## OFFICER'S REPORT

APPLICATION NUMBER: S6/2003/1311/FP

LOCATION: Wyndham Cottage, Camfield Place, Essendon

PROPOSAL: Erection of two storey side extension and rear conservatory

REVISED DRAWING  
 25-11-03  
 WYNDHAM COTTAGE  
 CAMFIELD PLACE  
 ESSENDON  
 MERTS ALISE  
 MR MRS J ADKIN

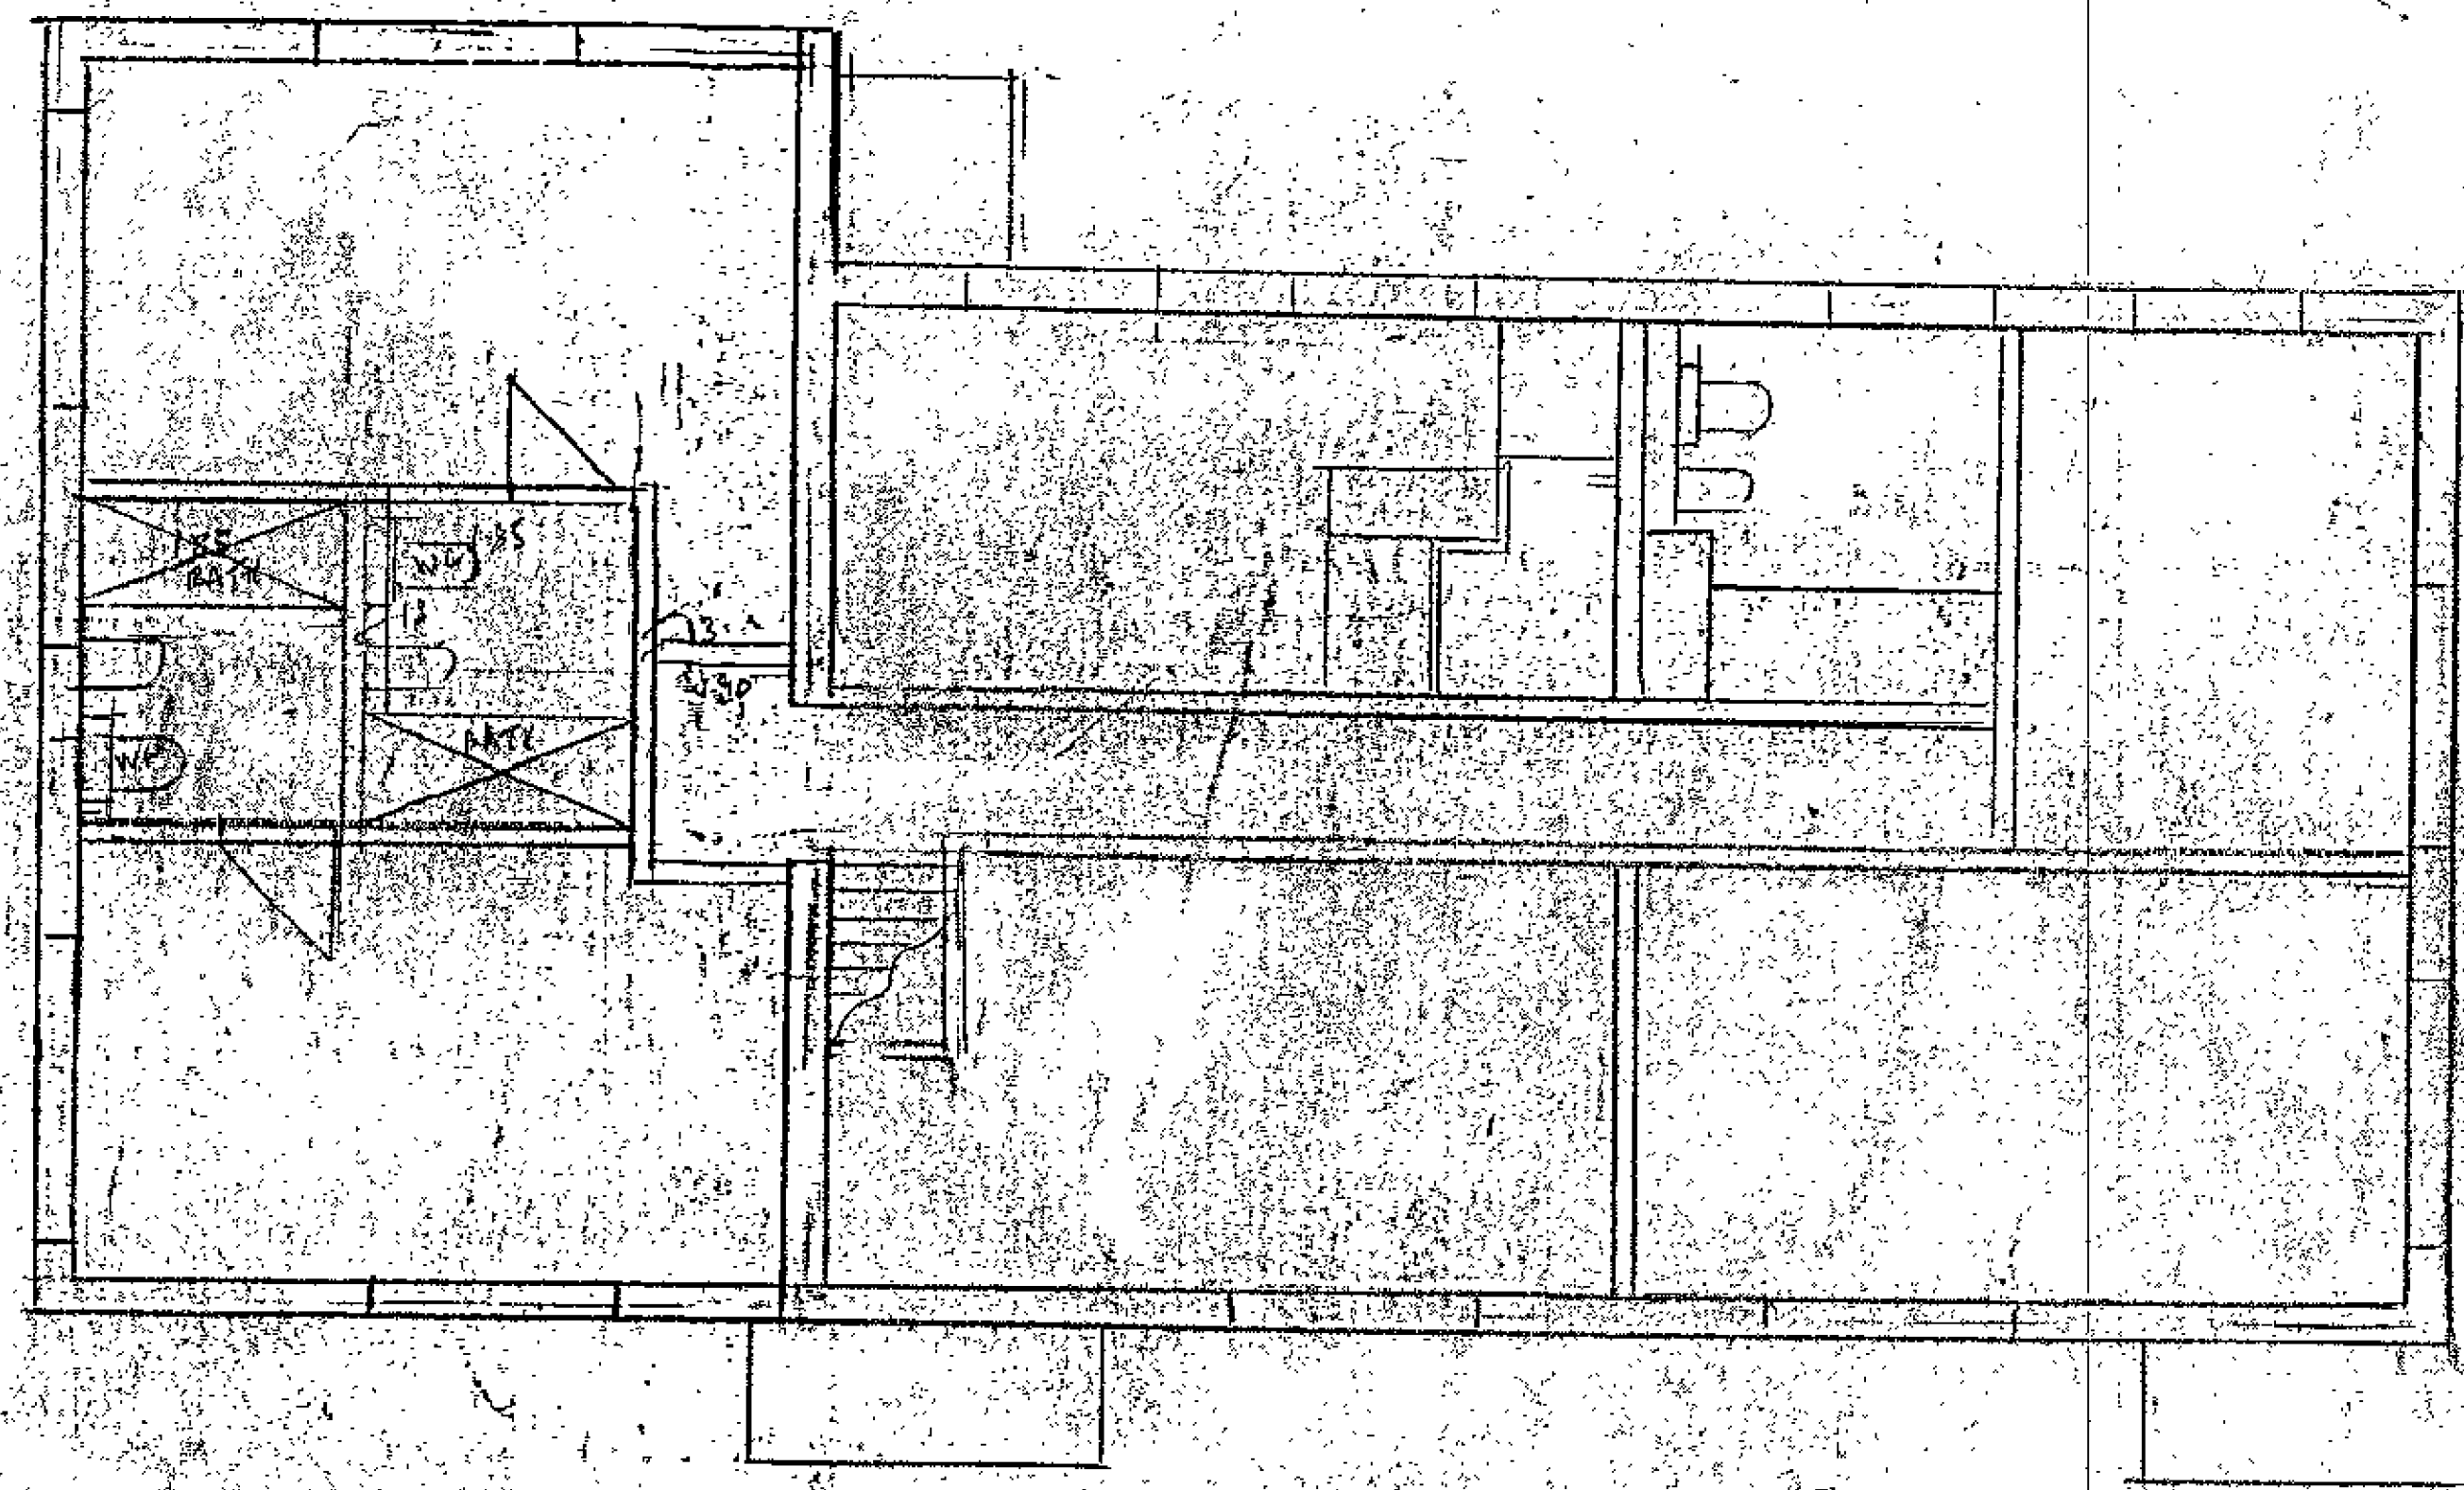
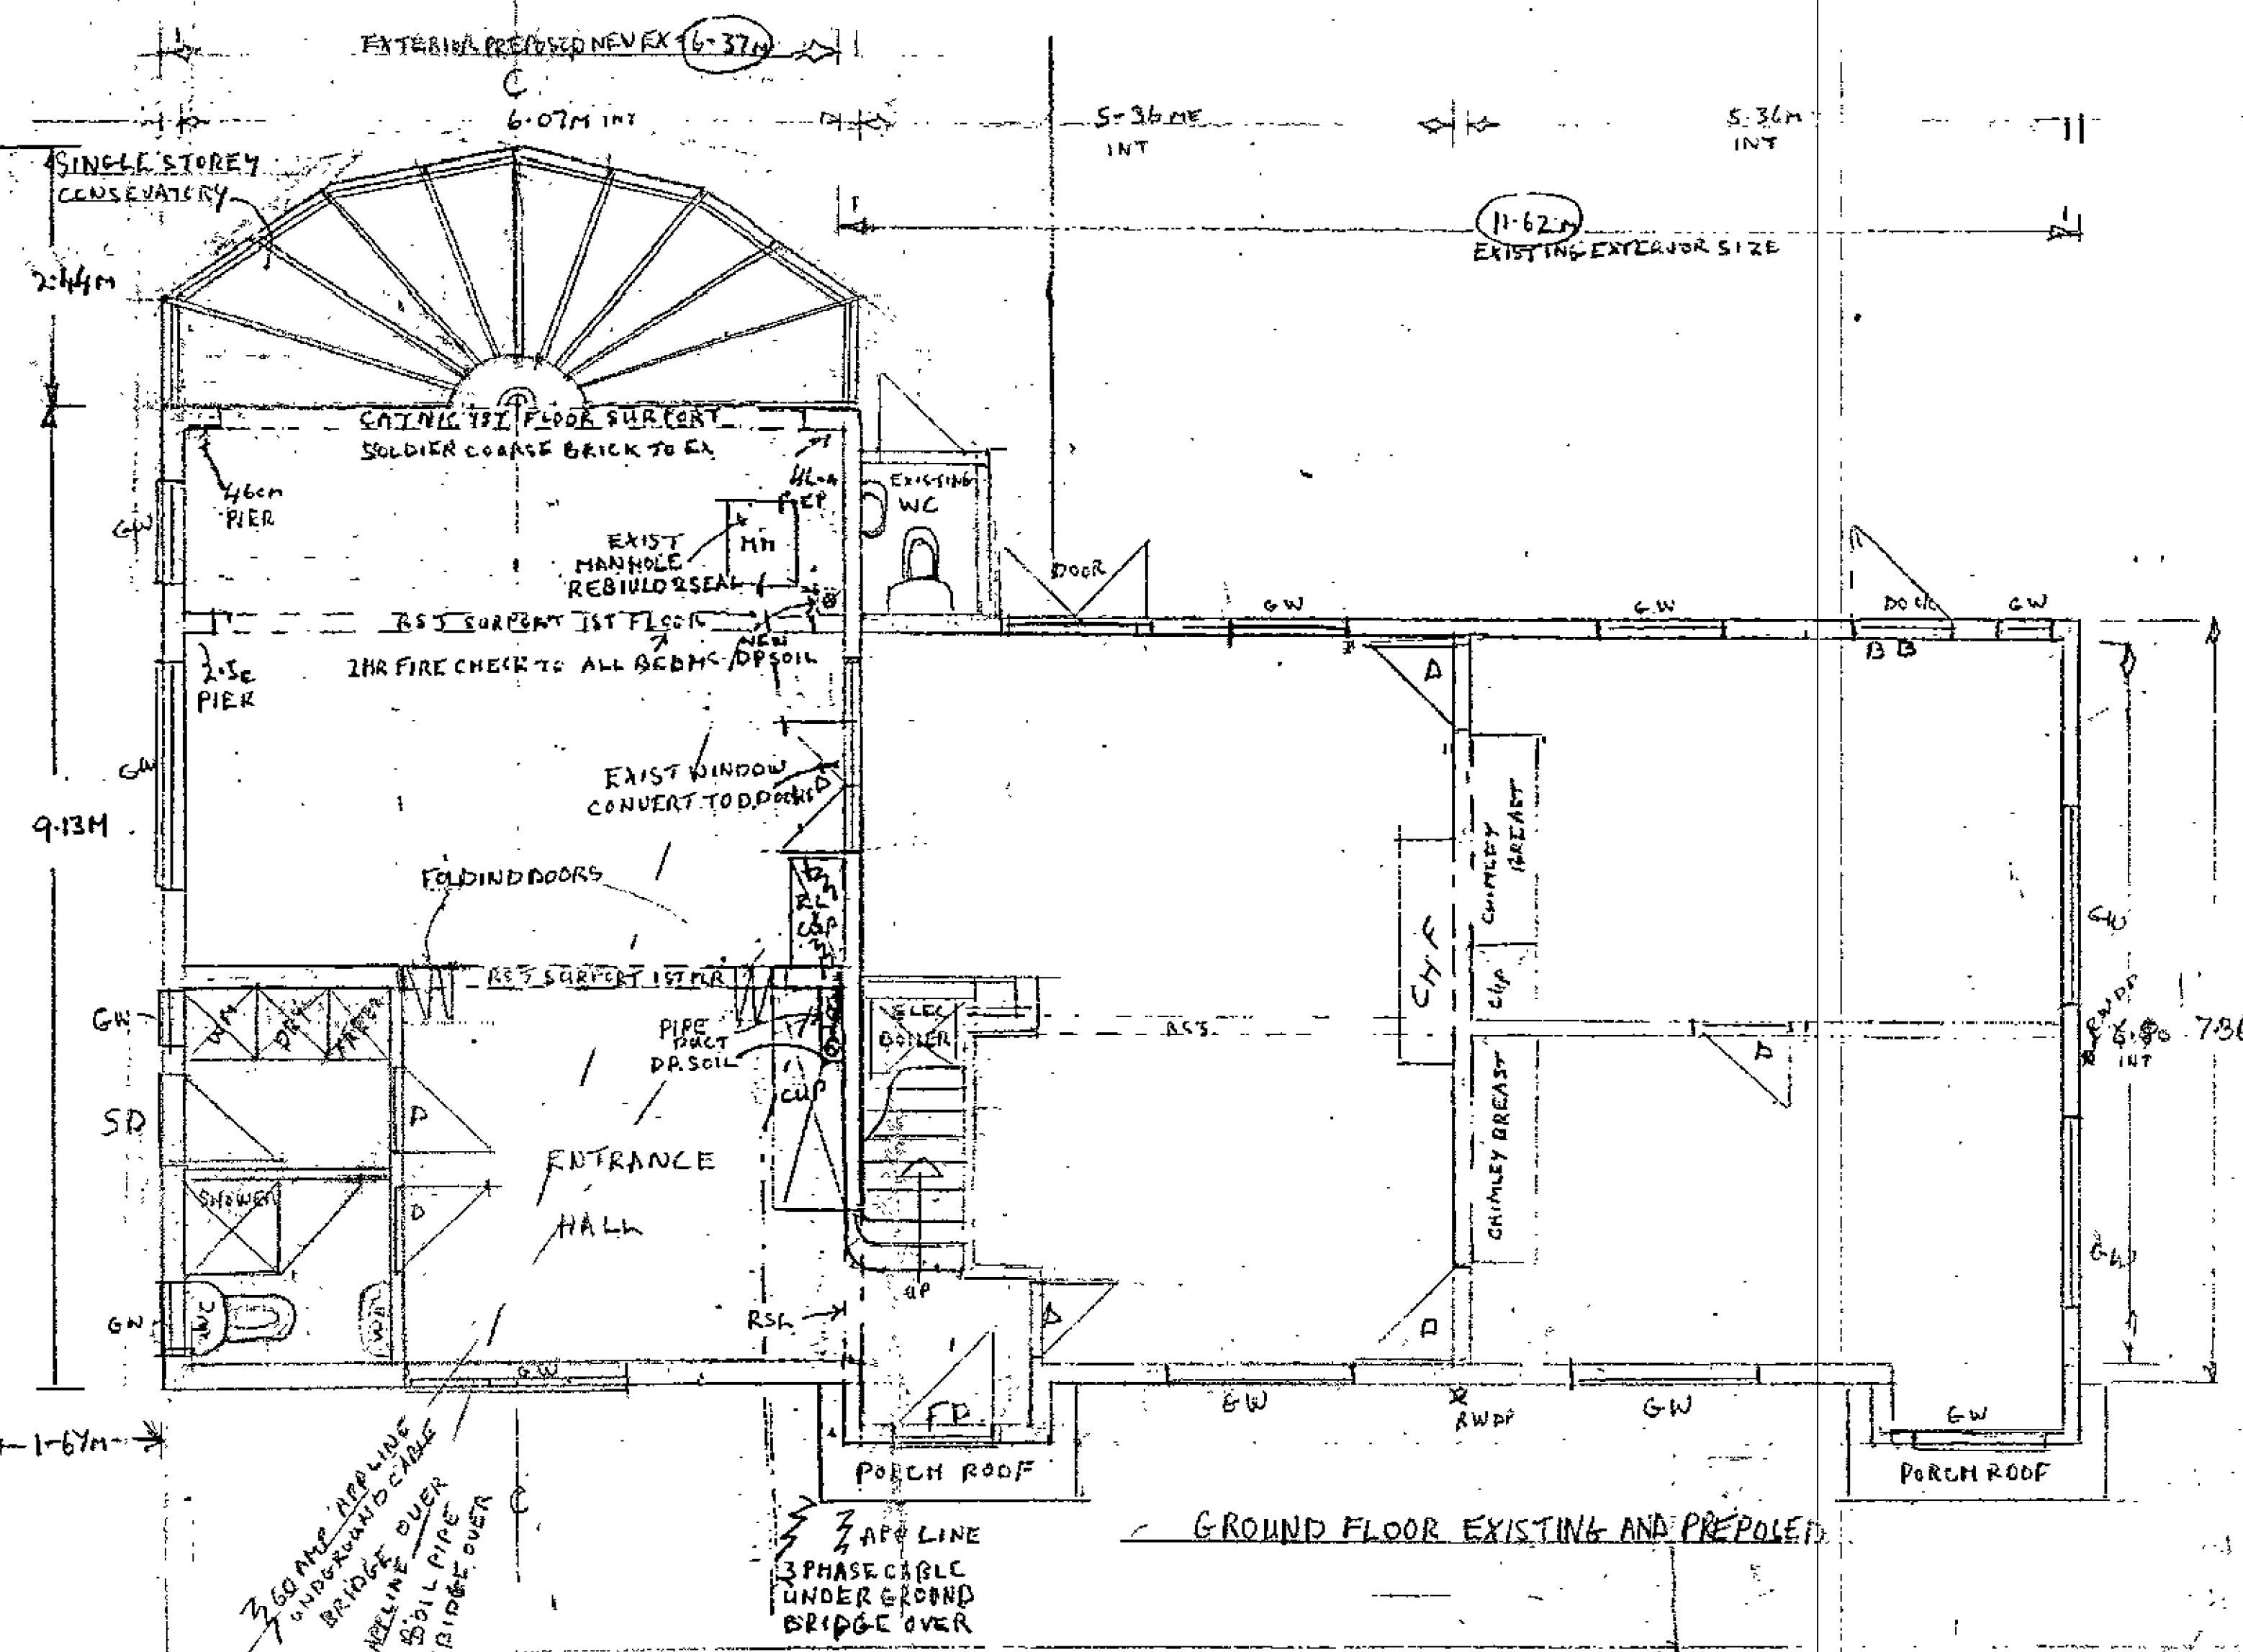
In terms of the Council's Residential Criteria, the application is also not acceptable. The extension would not be subordinate to the original dwelling and does not reflect the design or character of the house through the introduction of a gabled roof. The extension would also visually unbalance the appearance of the dwelling. Due to its isolated location and position away from the road the extension will accord with all other aspects of this policy.
